e: FP/13/20/PL

Further to my last e-mail I have had a meeting with the hotel owner who has confirmed that the land I thought may have been owned by WSCC is in fact owned by the hotel, accordingly I have attached an amended certificate A.

New outdoor seating area together with new fence, gate to promenade & planter

PROJECT The Beachcroft Hotel - Terrace
TITLE Proposed Site Plan
SCALE As Noted
DATE 11/01/20
DRG NO IBA/526/02
REVISIONS B

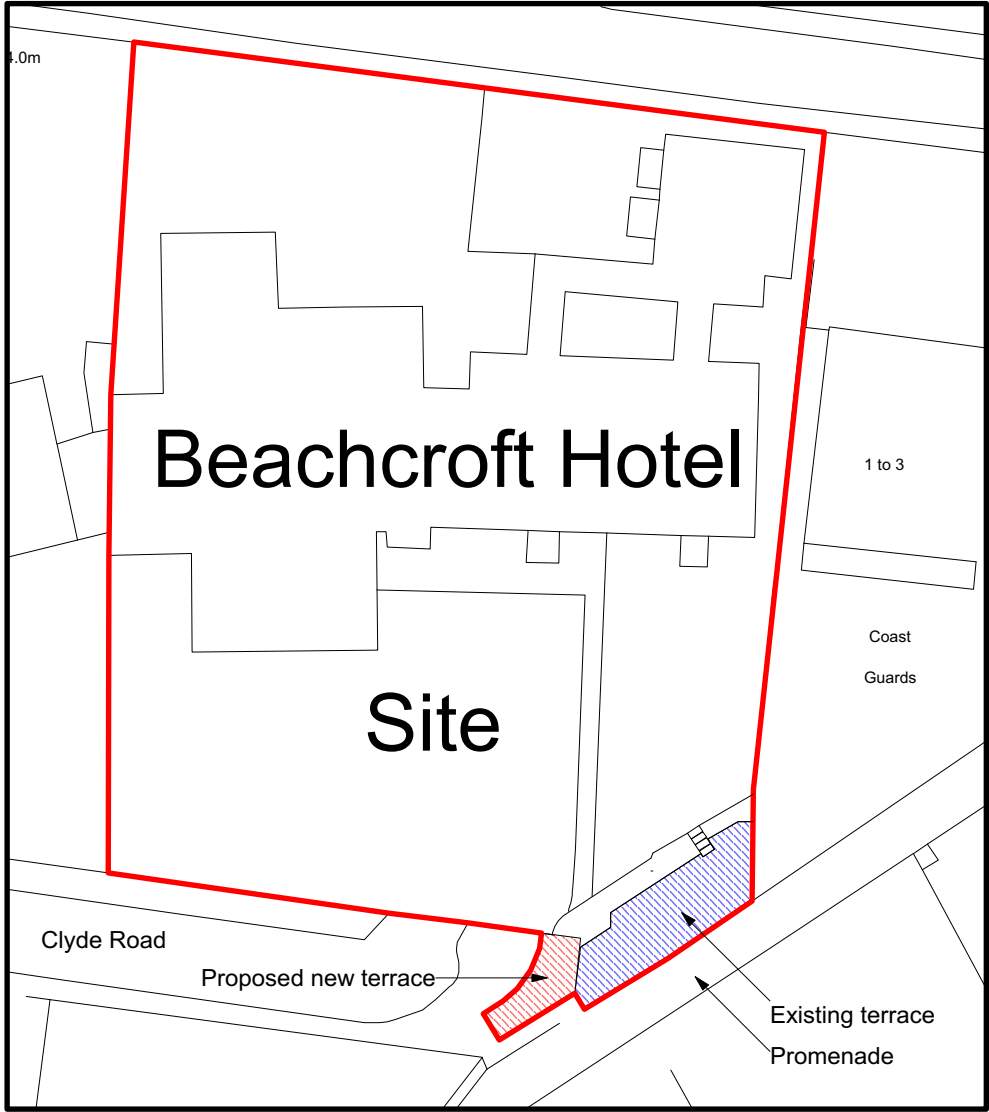
They applicant also wants to add a gate from the promenade to the terrace, subject to ADC engineers approval, as we need to remove a small concrete upstand at the head of the access ramp. We also want to extend the terrace back into the site over an existing flower bed and grassed area at the same height as the existing terrace.
